PRE-DESIGN CONFERENCE RECAP

PROJECT TITLE: Knights Of Columbus ZONE ATLAS/DRNG. FILE #: H-18/039  
 LEGAL DESCRIPTION: Lots 10 thru 19, Block 68, Bel-Air Addition (current Legal)  
 CITY ADDRESS: 2800 San Mateo Blvd. N.E.

June 14, 1985

REF: DRAINAGE PLAN FOR KNIGHTS OF COLUMBUS (H18-D39) RECEIVED MAY 30, 1984

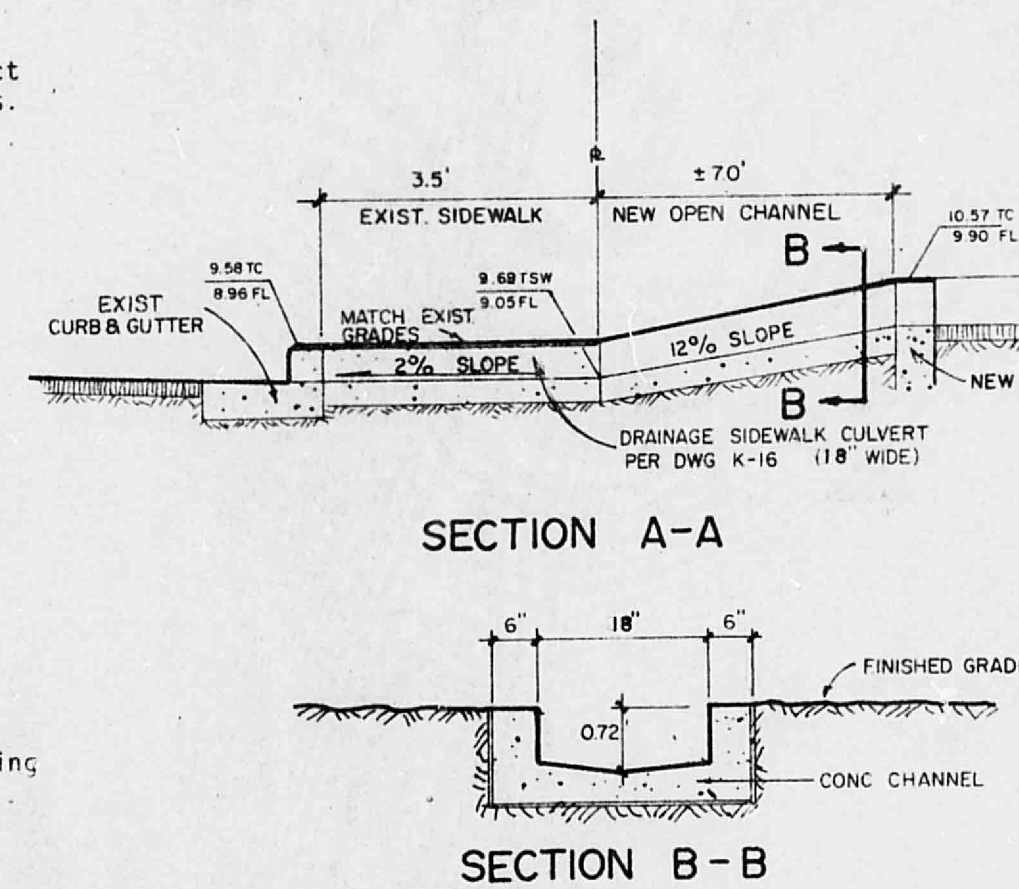
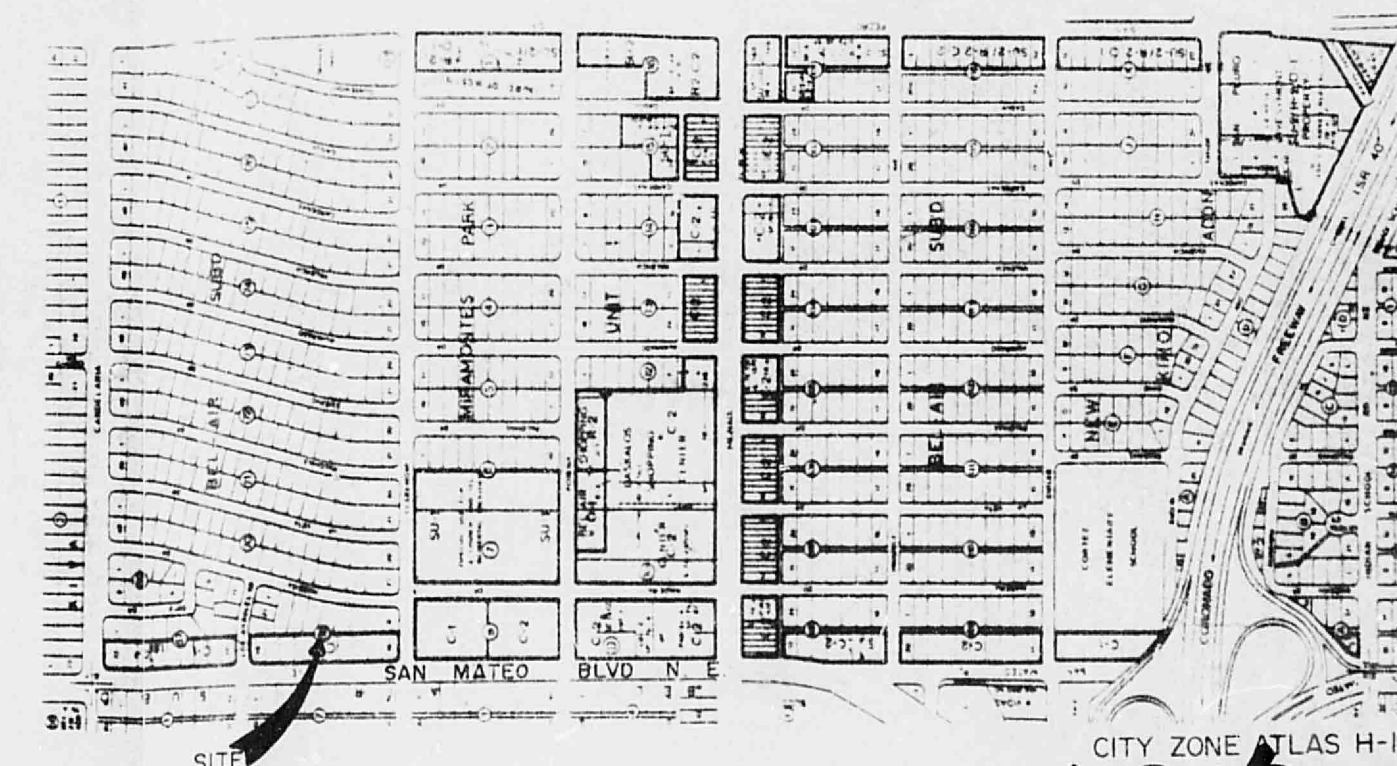
1. The drainage plan needs to be dated by the Engineer who prepared the plan.
2. Surface treatment on the site is unclear.
3. Contours and/or spot elevations within 25' of property lines are required.
4. Easement on the property must be identified.
5. Garden walls must be clearly identified.
6. Flow lines are needed or sufficient spot elevations to clearly define the flowpaths.
7. Internal contribution drainage areas are not clearly delineated.
8. Nuisance waters need to be contained on-site.
9. Drainage sidewalk culvert has wrong citation, please refer to the new Public Works Contract Document 85-1.
10. "Private Drainage Facilities Within City Right-of-Way/  
Easement" for the channel will need to be attached to the construction set for building permit approval.

11. A copy of a recorded plat eliminating lot lines or a drainage covenant for flows across lot lines is required.
12. Why are there no off-site flows contributing to this site?
13. Proposed and existing elevations at property lines are needed.

All comments received June 14, 1985 to the above referenced have been addressed on new submittal. An approved "Private Drainage Facilities Within City Right-of-way/ Easement" documents will be attached to construction drawings and a filed replat eliminating lot lines will be submitted to your office for review.
